Recommendation Report for Planning Permission for Works or Extension to a Dwelling

REF NO: R/222/21/HH

LOCATION: 42 Pigeonhouse Lane
Rustington
BN16 2BE

PROPOSAL: Single storey rear extension and hip to gable loft conversion with 2 x dormers following the demolition of existing rear conservatory

A :: Proposed First Floor Plan
03 scale: 1:100

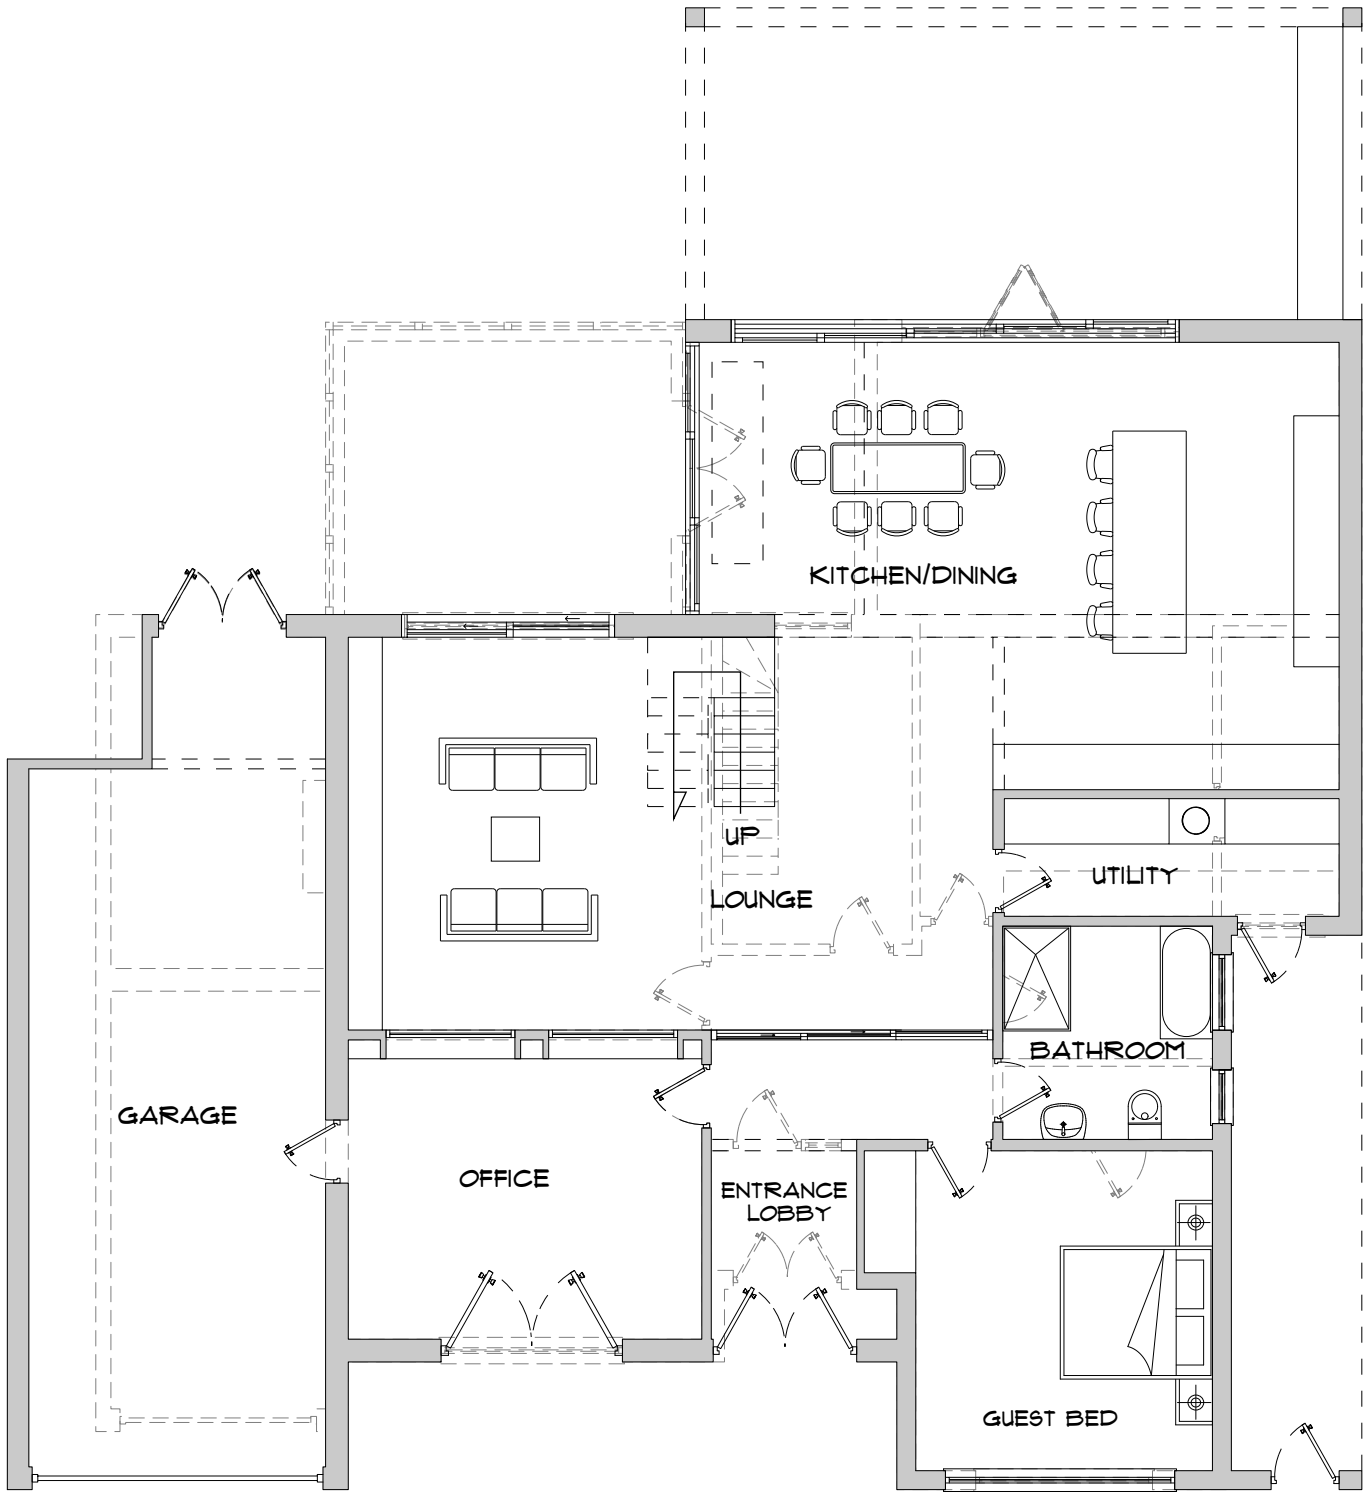
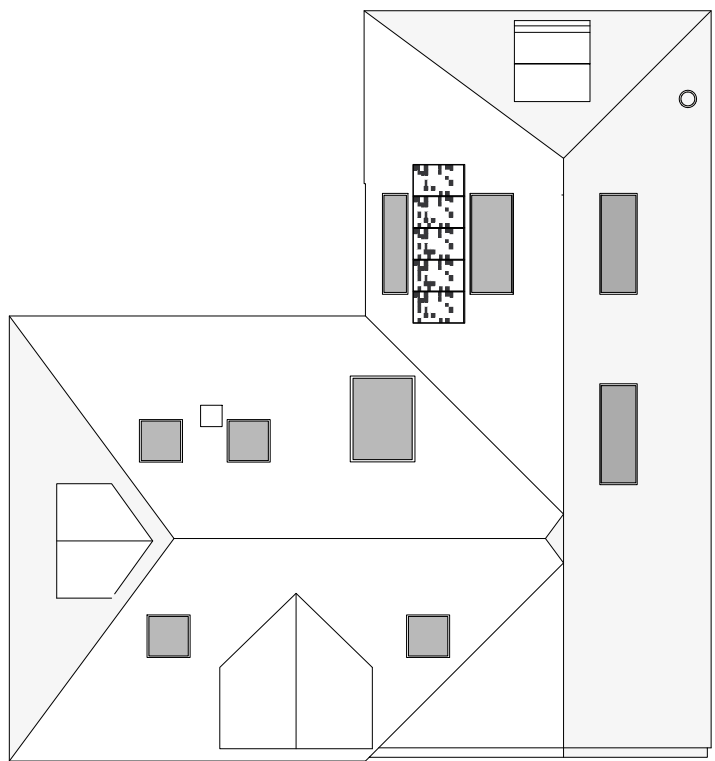
The alterations are not considered to result in adverse harm upon amenity. To the southern elevation the extended hipped roof above the garage and appropriately sized dormer sit within a small footprint increase of 1.6m to the garage, leaving a minimum of 1.42m separation gap between the wall of the garage and the boundary. Amendments during the course of the application have reduced the overhang of the eaves to the southern elevation from 1.1m to 550mm. As it had been originally designed there were concerns that the roof structure to the south eastern corner of the building would visually merge in with the roof line of the property to the south, when viewed from the street, given the angles of the

To the rear, above the existing extensions the proposed east/west running ridge line with a gable to the front and hipped roof to the rear, will be 4m in depth although at ground floor it will be an open space. The roof structure will be located over 12.5m away from the rear boundary, so even if the space underneath the roof is filled in at a future point, a rear garden over Design Guidance recommended levels will be retained. The rear projection of roof is within allowed limits set by the 45-degree rule when applied to the property to the north, which would be the most affected neighbour and the proposed rear roof extension would run no nearer to the boundary than already exists. The increase in bulk of the roof at this point on the property to the north is not of concern as it slopes away from the boundary, it is also noted there is a good separation distance between the application site and No. 40.

A 04

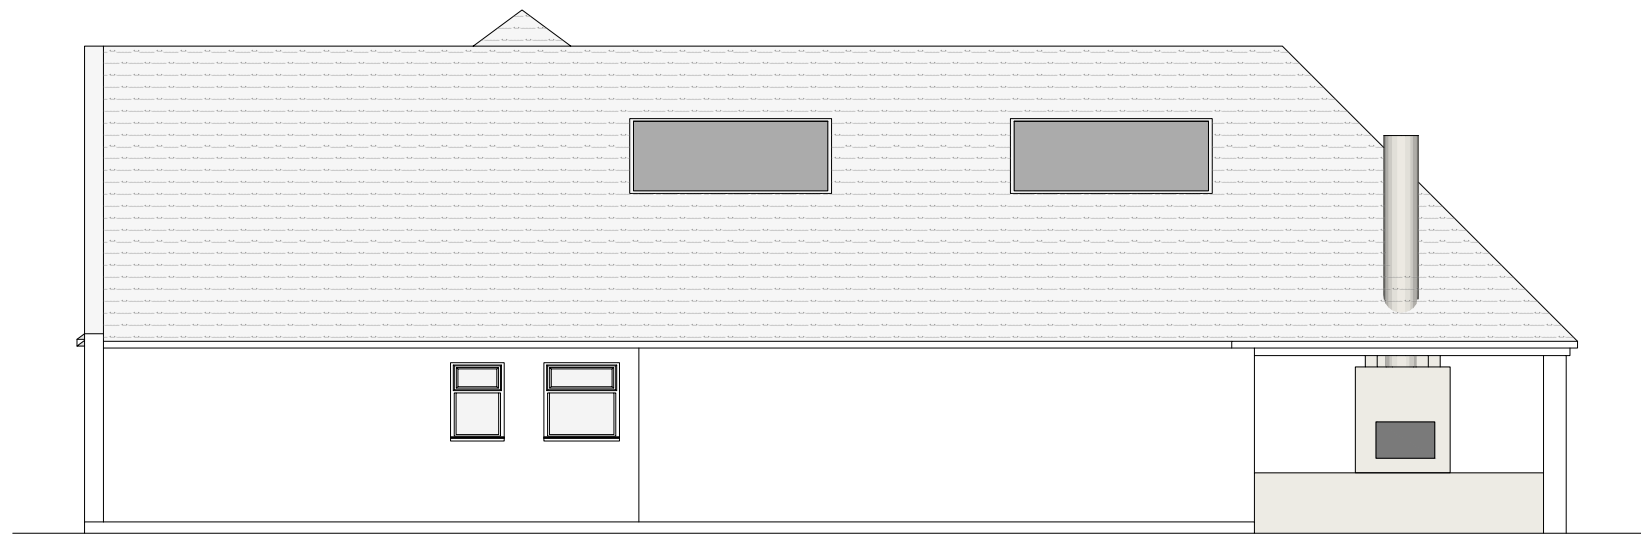
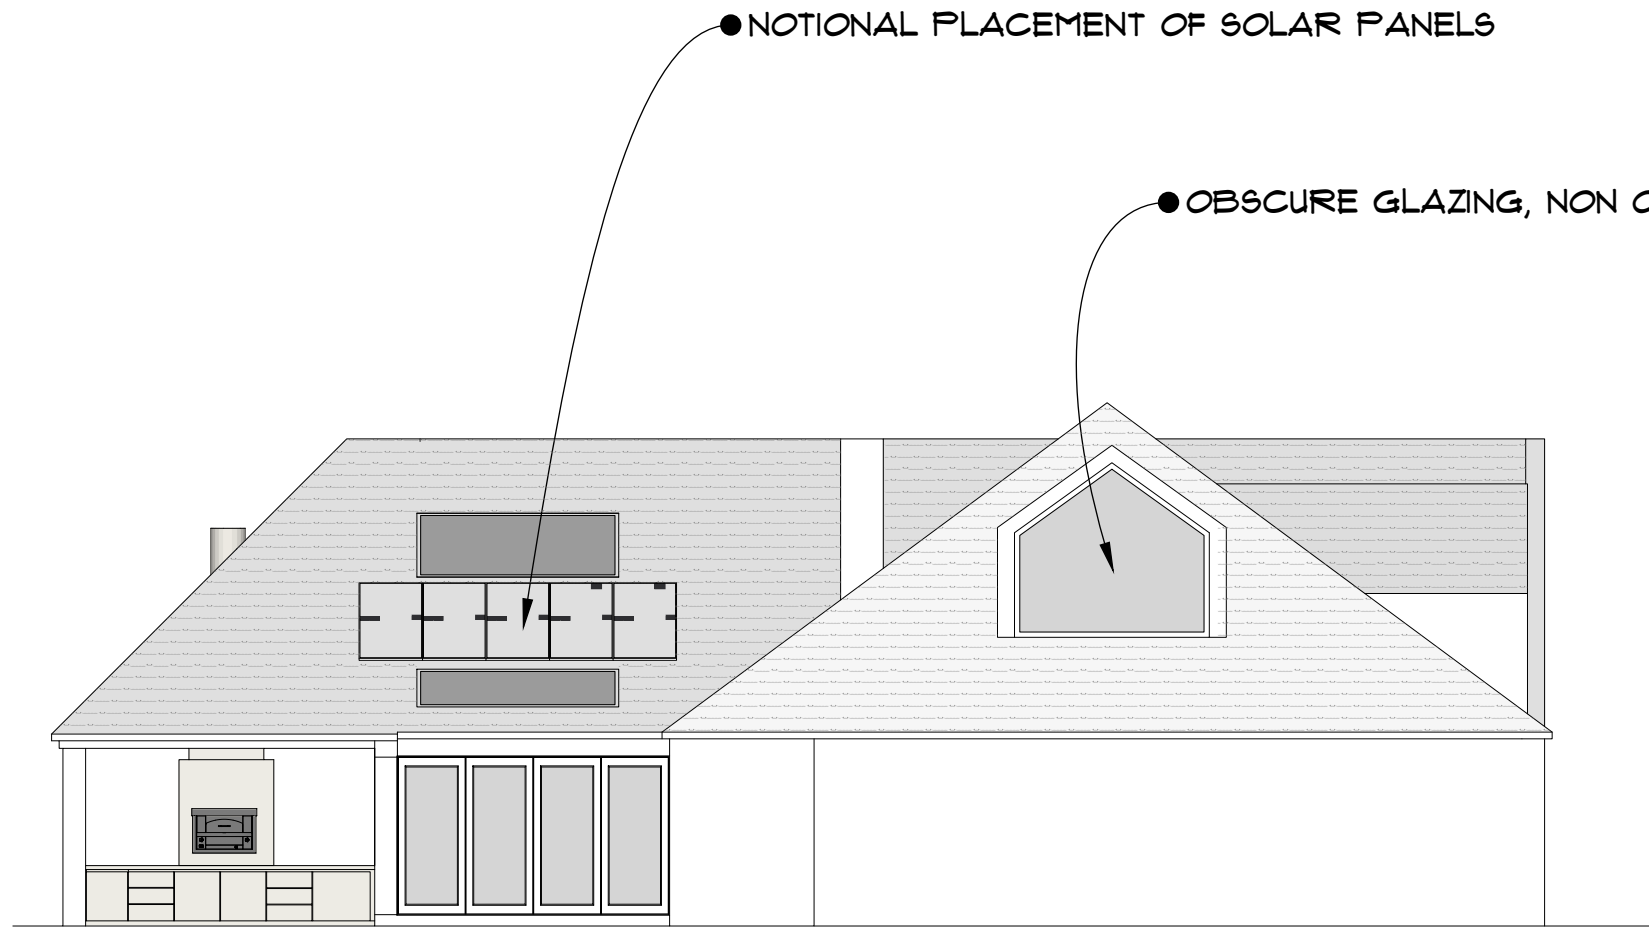
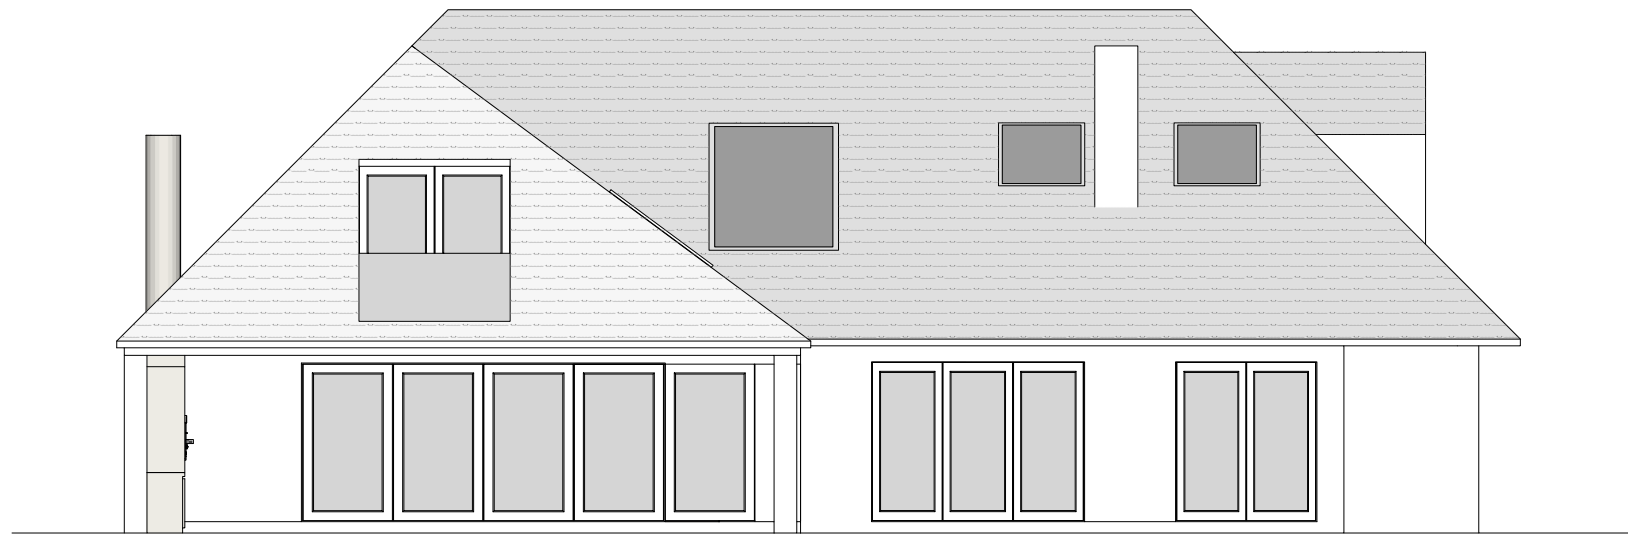
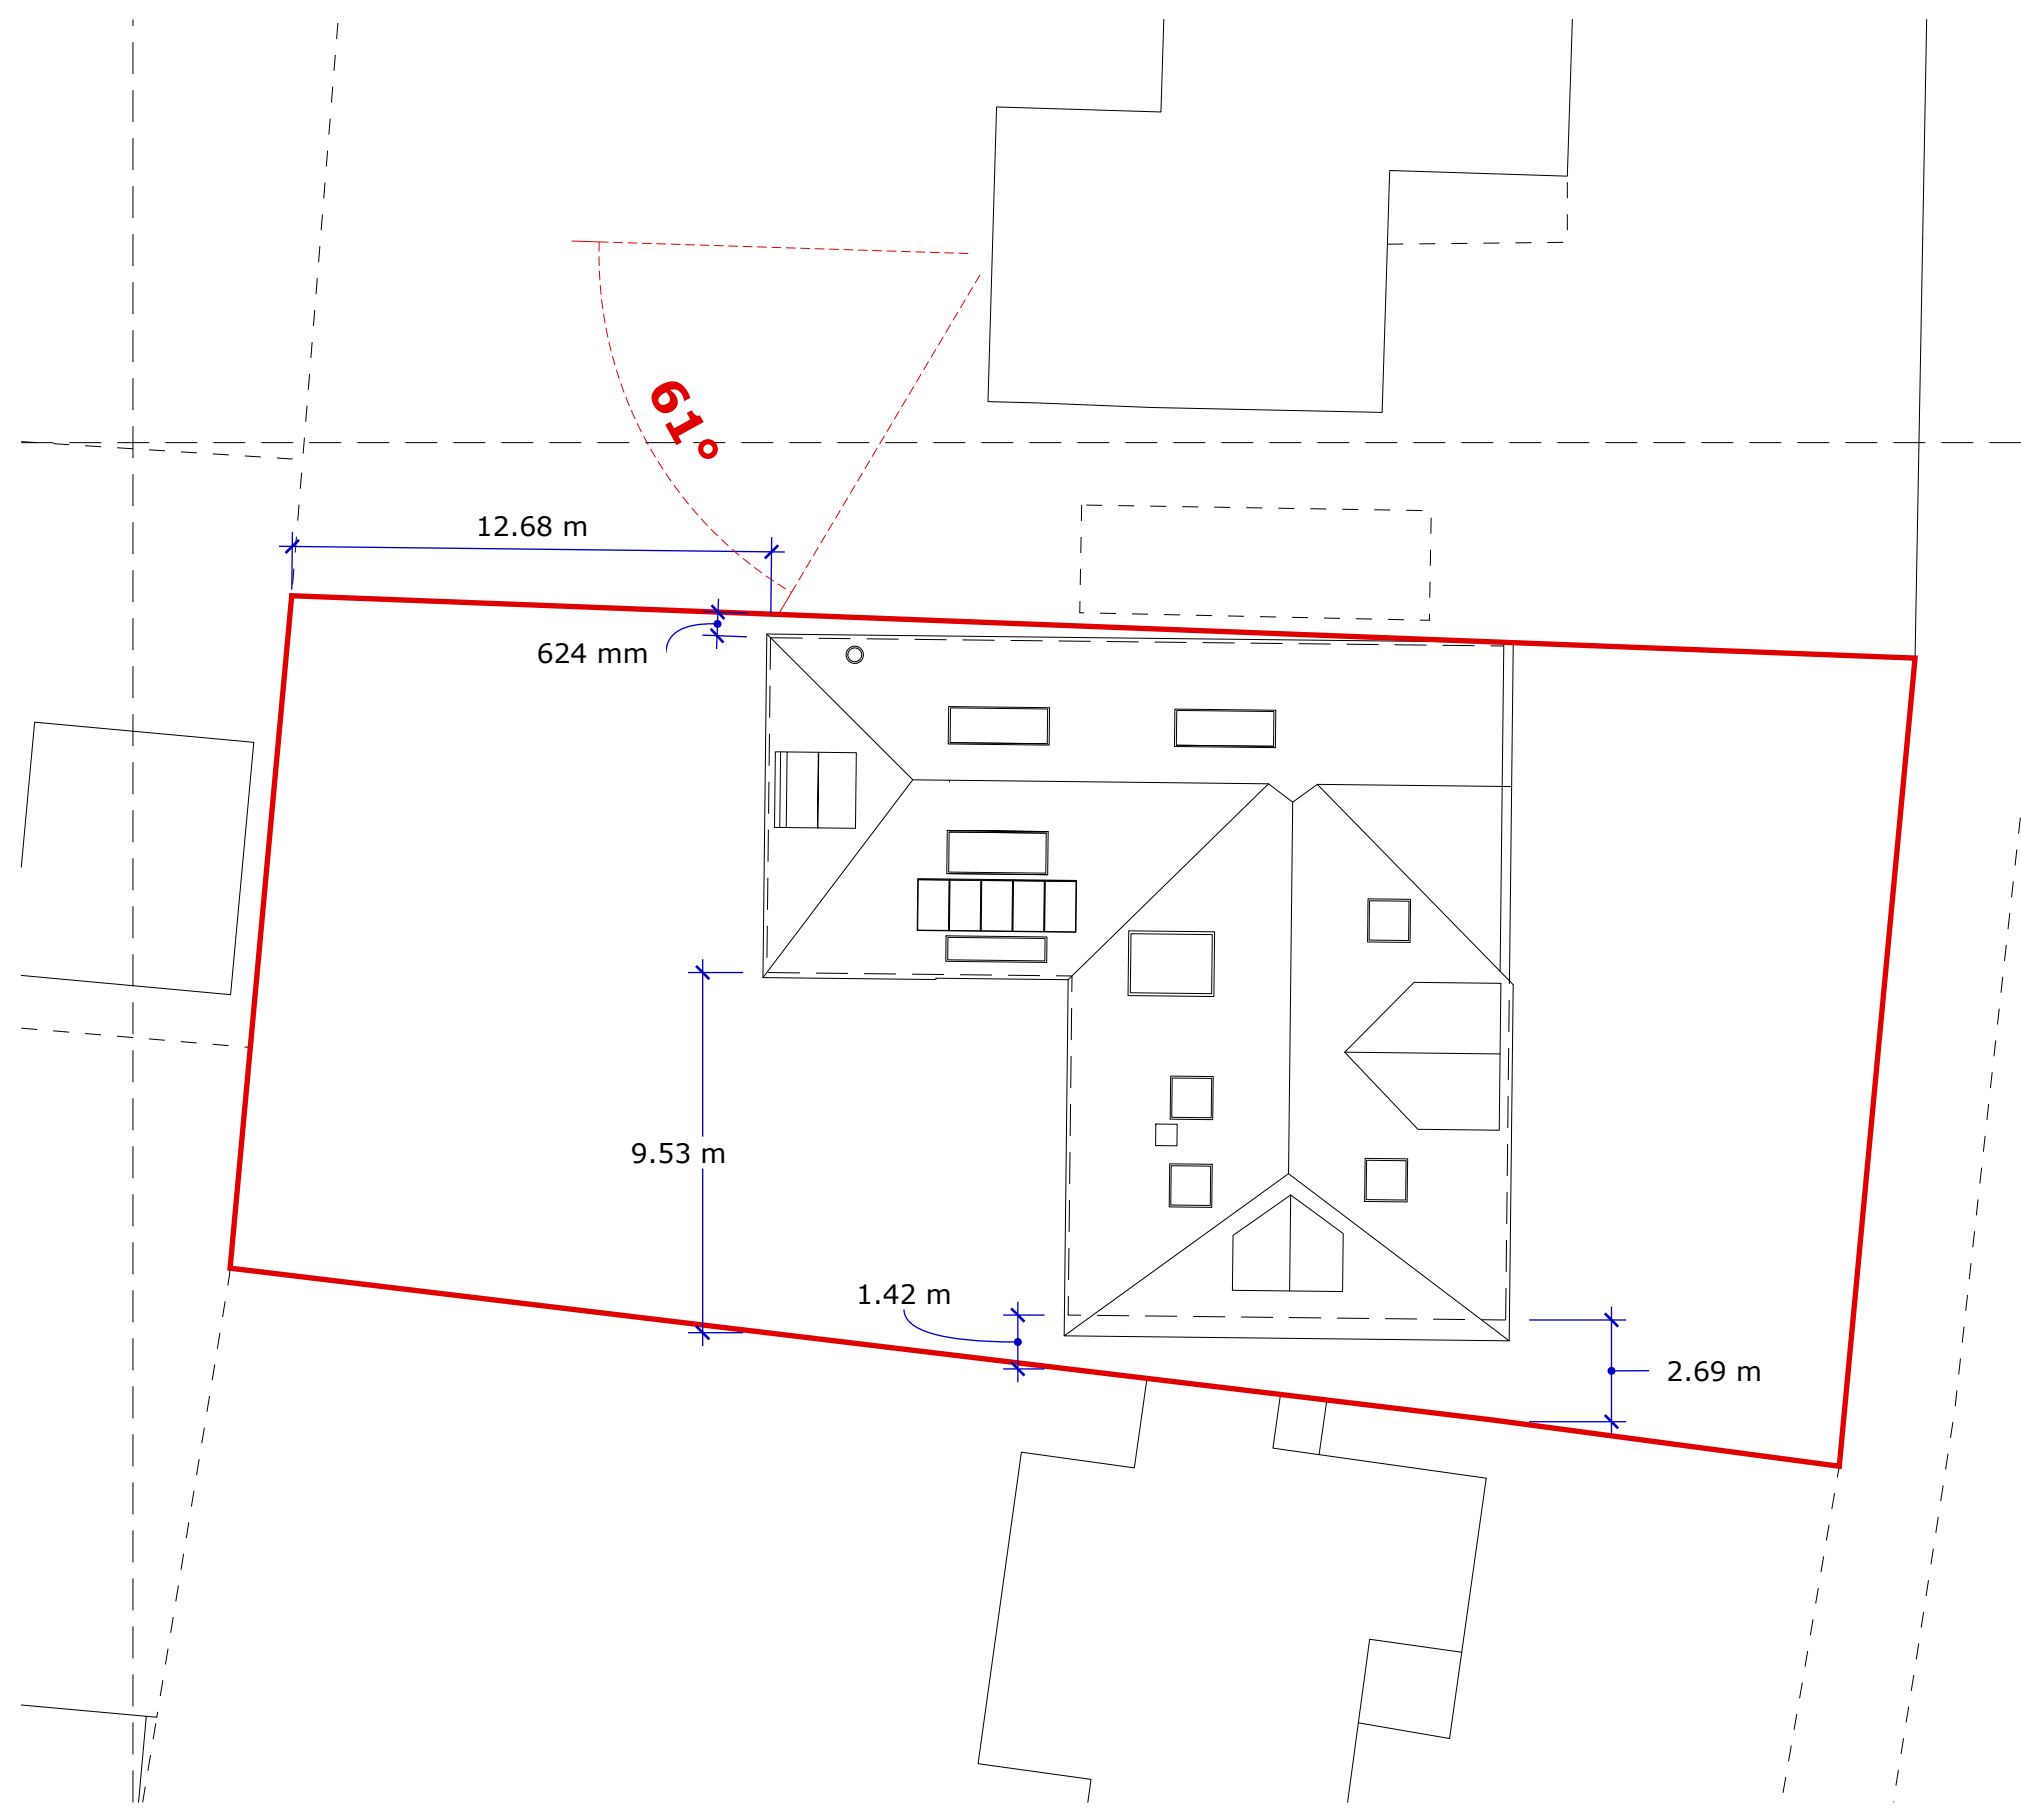
- Overlooking to properties in Frobisher Way.
- Redline to boundary.
- Overlooking windows and balcony facing property to the North.
- Loss of light for property to the North.
- Chimney will cause smoke to blow over property.
- Dormer facing south will cause a loss of privacy.

A front dormer is proposed. There is one existing, however the proposed is larger and features a balcony facing east.

The primary ridge will be lengthened towards the southern side above the garage which itself is also being widened by 1.6m, and the hipped roof will include a southern facing obscure glazed dormer window to the Master Suite. The design of the roof above will remain hipped in line with the host dwelling to ensure it appears integrated and the scale of the dormer appears appropriate and is not unduly dominant upon the roof slope.

buildings. Now, there will be a clear separation distance, totalling about 800mm between the roof structures. Due to the design of the roof, extending away from the boundary, it does not appear overbearing. The dormer fronts an existing side dormer to No 44. The window will be obscured glazed to ensure no adverse views are available.

An inset balcony will be proposed, with the balustrade being built within the roof structure, this would highly restrain any new views achievable by the balcony over the property to the north. Views to the south into the rear garden of 19 Frobisher Way will be interrupted by the mature planting to the rear boundaries of both properties and various garden buildings to the property in Frobisher Way. Views into the rear of the the bungalows on Frobisher Way are not of concern due to a separation distance of over 45m. It is considered that there will be no overbearing, overshadowing or loss of privacy due to the increased roof structure or the west facing inset balcony.

The agent has confirmed that the north facing Velux roof lights will be above 1.7m from finished floor level and as such will cause no loss of privacy.

- Rooflights are within Permitted Development.
- Balcony facing Frobisher Way is recessed within the roof pitch with the balustrade within the hipped roof.
- All North facing windows are Velux type and will be 1700mm from FFL.
- Boundary lines have been taken from OS maps.
- Outdoor Chimney will only be used for BBQs during summer months and will take smoke over gardens.
- Dormer to south will be non-opening below 1700mm and contain obscure glass.

- 3 The dormer to southern elevation hereby approved shall be non-opening below 1.7m above finished floor level and fully obscured windows prior to the first use of the rooms. The velux style roof windows to the northern elevation hereby approved shall not have a cill level lower than 1.7m above finished floor level prior to the first use of the rooms. The windows shall be retained as obscure glazed/non-openable below 1.7m and the rooflights shall remain non opening below 1.7m in perpetuity.
